Our Reference: SYD17/00866/02

Your Ref: SSD 8544

Department of Planning & Environment
GPO Box 39
SYDNEY NSW 2001

**GLEBE ISLAND AGGREGATE HANDLING AND CONCRETE BATCHING FACILITY
GLEBE ISLAND, JAMES CRAIG ROAD, ROZELLE – NOTICE OF EXHIBITION**

GLEBE ISLAND 1 - Proposed Hanson Aggregate Facility & Concrete Batching Plant

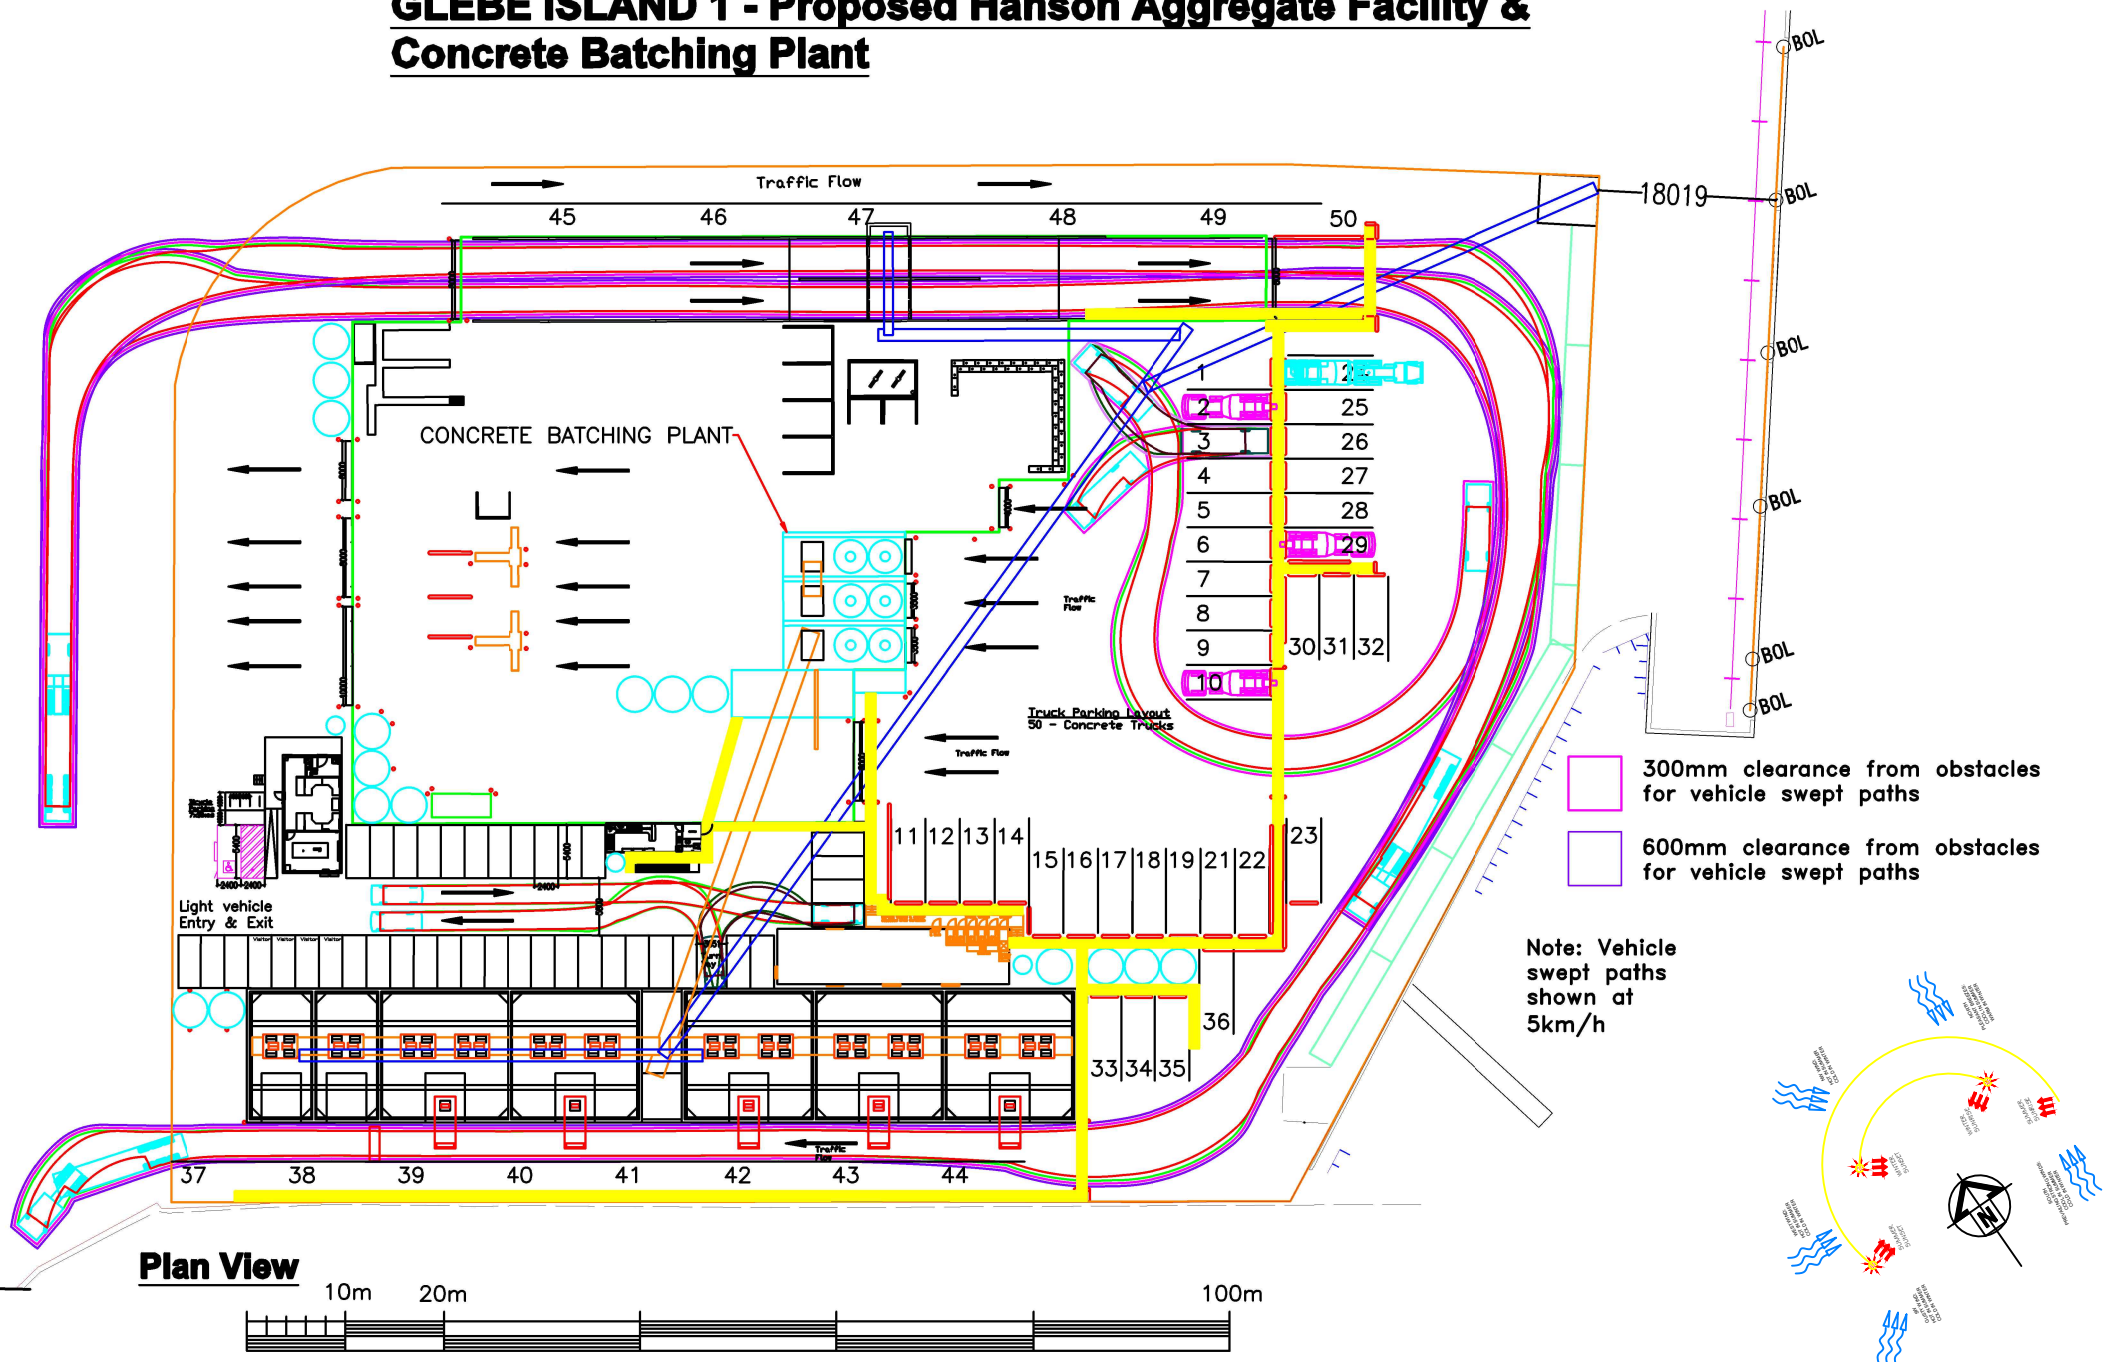
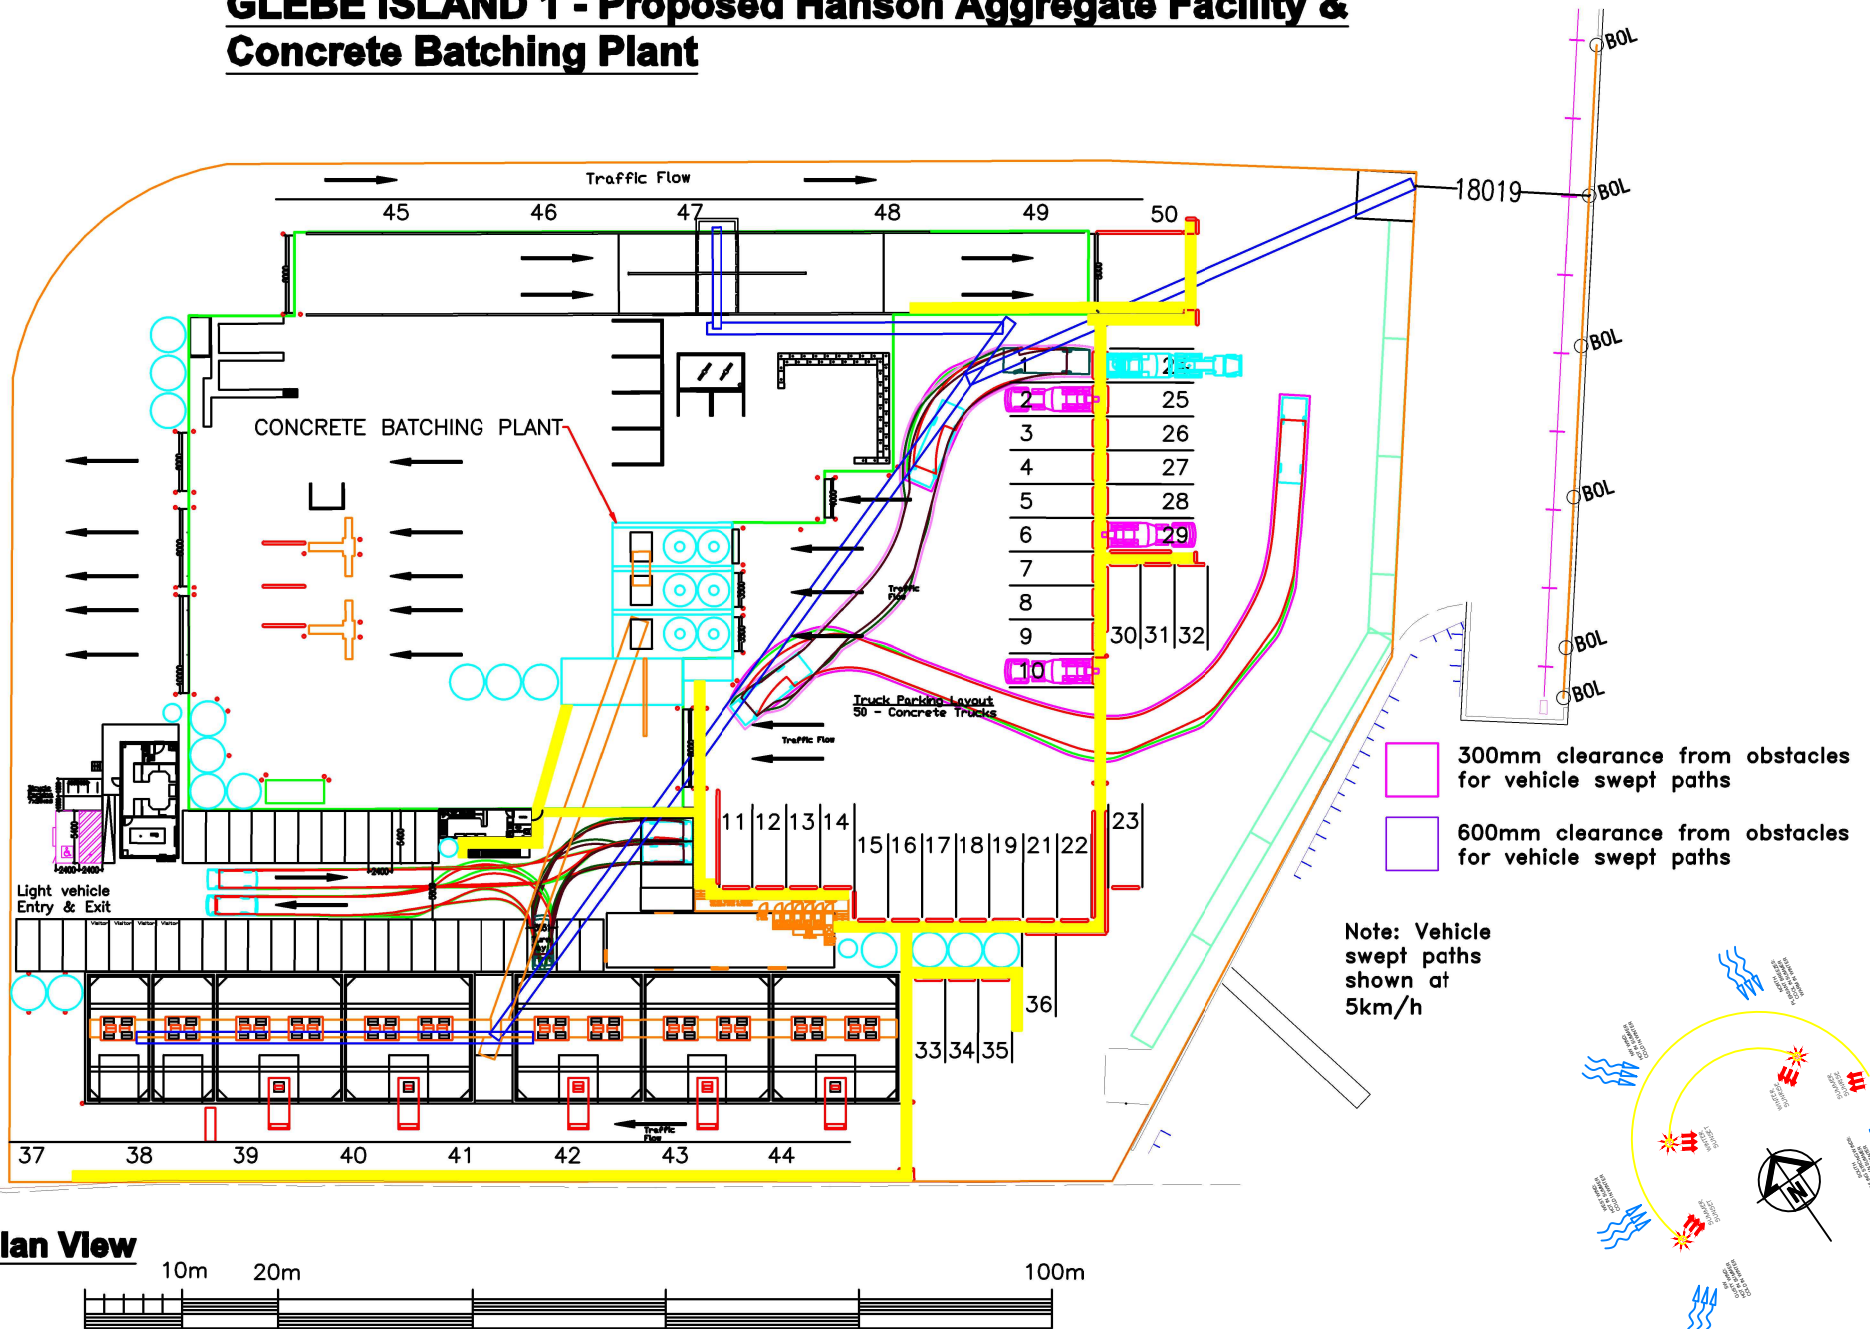
1. A swept path assessment of Cement, Aggregate and Concrete trucks that are proposed to turn right at the intersection of The Crescent / James Craig Road. Roads and Maritime is concerned that additional large trucks will reduce the ability for two vehicles to turn side-by-side, leading to a reduction in capacity of the right turn movement beyond that envisaged. Additional information is requested to be provided on whether the traffic capacity of the right turn is likely to reduce based on the swept path assessment and if so, this is to be reflected in the traffic modelling.
